Phone: 0300 123 6780
Email: [REDACTED]
Your ref: 3/2025/0246
Our ref: 3/2025/0246/HDC/KW
Date: 28 April 2025

Location: Ribblesdale House Ribblesdale Avenue Clitheroe BB7 2HZ
Proposal: Proposed single-storey garage and vehicular access.
Grid Ref: 374224 442543

The Local Highway Authority (LHA) are in receipt of an application for the proposed single-storey garage and vehicular access at Ribblesdale House Ribblesdale Avenue Clitheroe BB7 2HZ.

PROPOSED GARAGE SITE PLAN

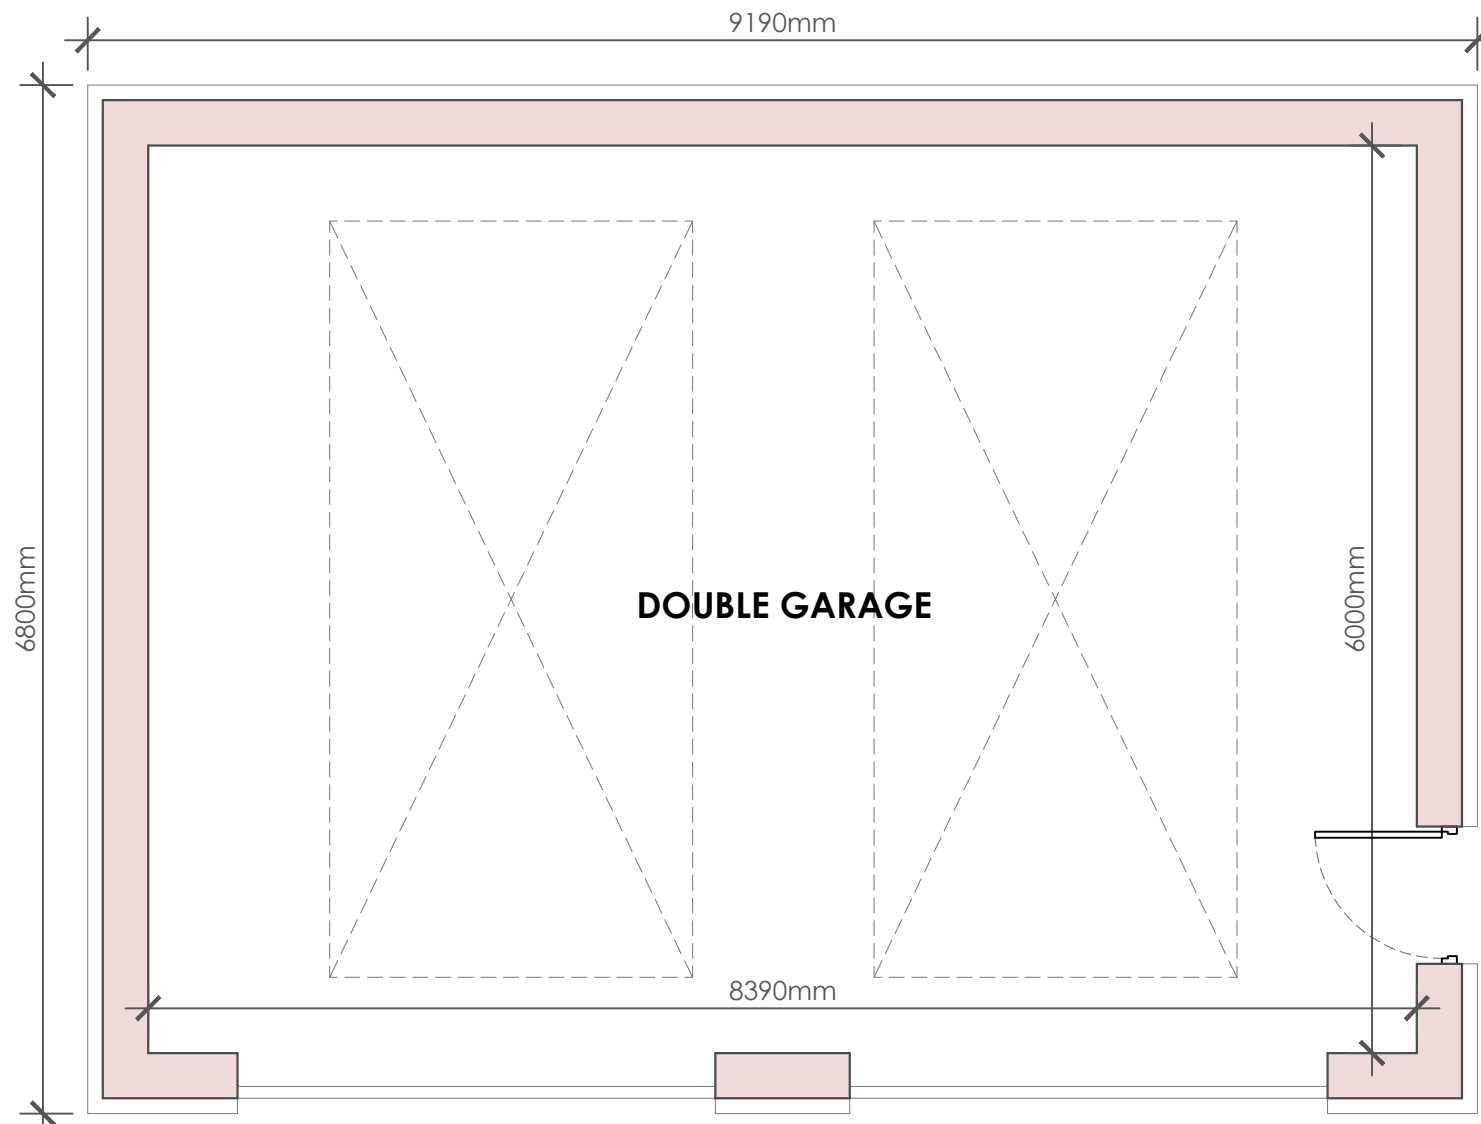
The proposal is for a double garage which meets the LHAs recommended minimum internal dimensions of 6m in length and 6m wide. An additional area around the garage is shown on the site plan, which provides turning provisions so vehicles can enter and leave in a forward gear. Given the proposed access location, room to support ingress and egress in a forward gear should be retained for the lifetime of the development.

Whilst a drop kerb is in place at the proposed access, the LHA is of the opinion that this is to support pedestrian movements and that alterations may be required in order to support vehicle movements, such as relocating the existing utility chamber and the highway drain within the carriageway. As such the Applicant should enter into a section 171 agreement of the Highways Act 1980. As the area is accessed from the adopted highway it must be properly consolidated and surfaced in bound porous materials, not loose stone, gravel or grasscrete.

The utility chamber situated at the proposed access point may require relocation, as such the applicant should discuss the relocation of the chamber directly with the utility provider. The applicant should be aware that this type of work would be at the expense of the applicant.

1. The parking and manoeuvring areas shall thereafter always remain available for parking of vehicles associated with the dwelling. Driveways/vehicle parking areas accessed from the adopted highway must be properly consolidated and surfaced in bound porous materials, (not loose stone, gravel or grasscrete) and subsequently maintained in good working order at all times thereafter for the lifetime of the development.

2. The surface water from the approved driveway should be collected within the site and drained to a suitable internal outfall. Prior to commencement of the development details of the drainage strategy shall be submitted to and approved in writing by the Local Planning Authority. The scheme shall be implemented in accordance with the approved details.

3. All gates and associated mechanisms to be located outside the adopted highway and the gates to have physical restraints to prevent the gates from opening onto the adopted highway.
